# IMMINGHAM EASTERN RO-RO TERMINAL

Response to Beckett Rankine Design

Document 10.2.91

### **IMMINGHAM EASTERN RO-RO TERMINAL DEVELOPMENT**

Figure 1-1. Vessel Impact Protection Structures

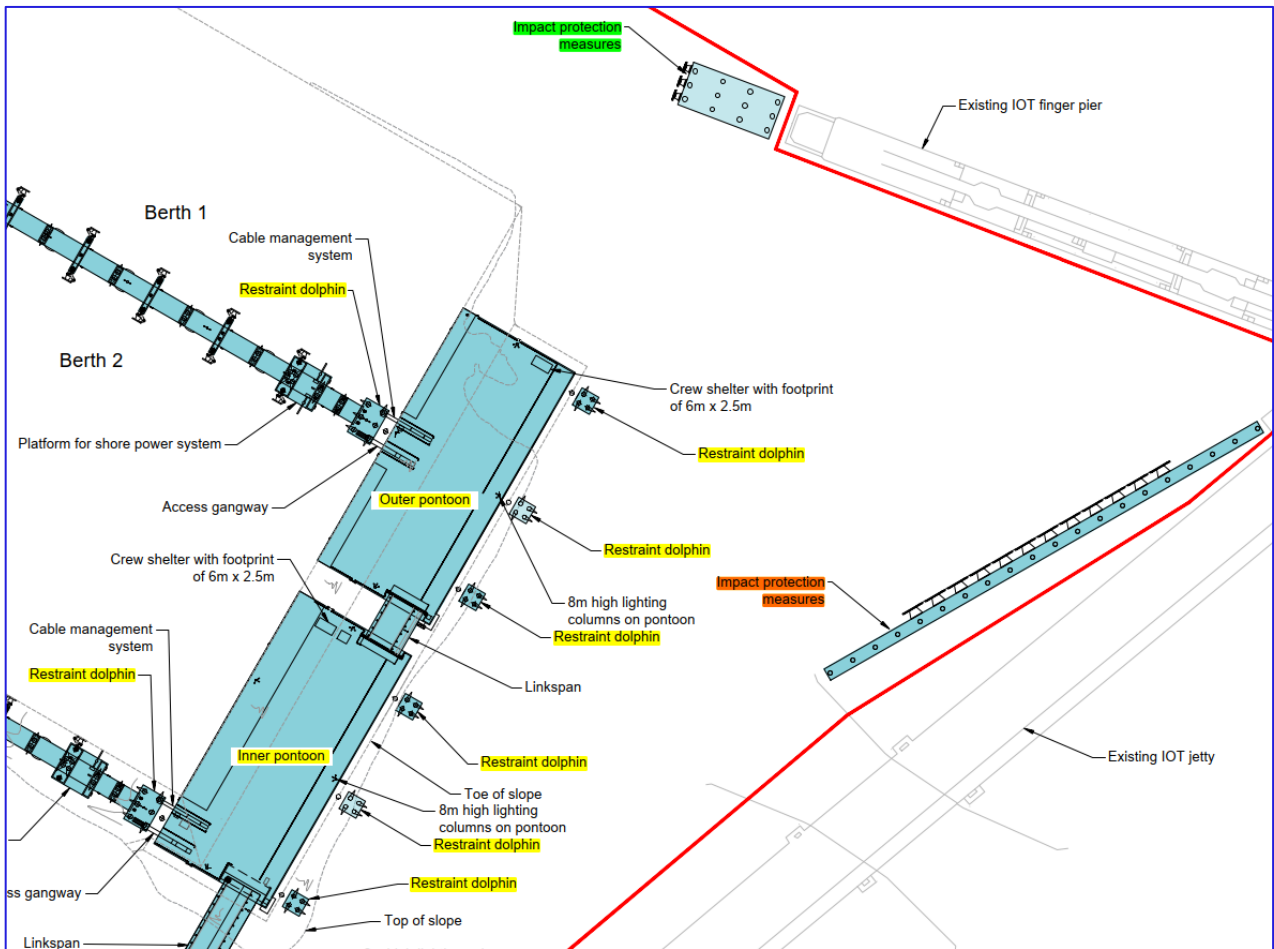
1.2.3 – The design has considered that the impact energy will be absorbed within a 2.5m displacement of the structure. The additional 2.5m is contingency for future design development and there is no need nor benefit derived from placing the infrastructure closer to the finger pier. This is a Design Basis document and it presents a minimum criteria for the future phases of design to achieve. This distance was selected with consideration of:

- The layout and the orientation of the existing and proposed structures.
- Space for construction and future maintenance.
- That a vessel on IOT Berths 6 or 8 is not expected to extend beyond the concrete deck of the Finger Pier, indicatively 18m from the nearest corner of the proposed dolphins; and
- Preliminary concept development.
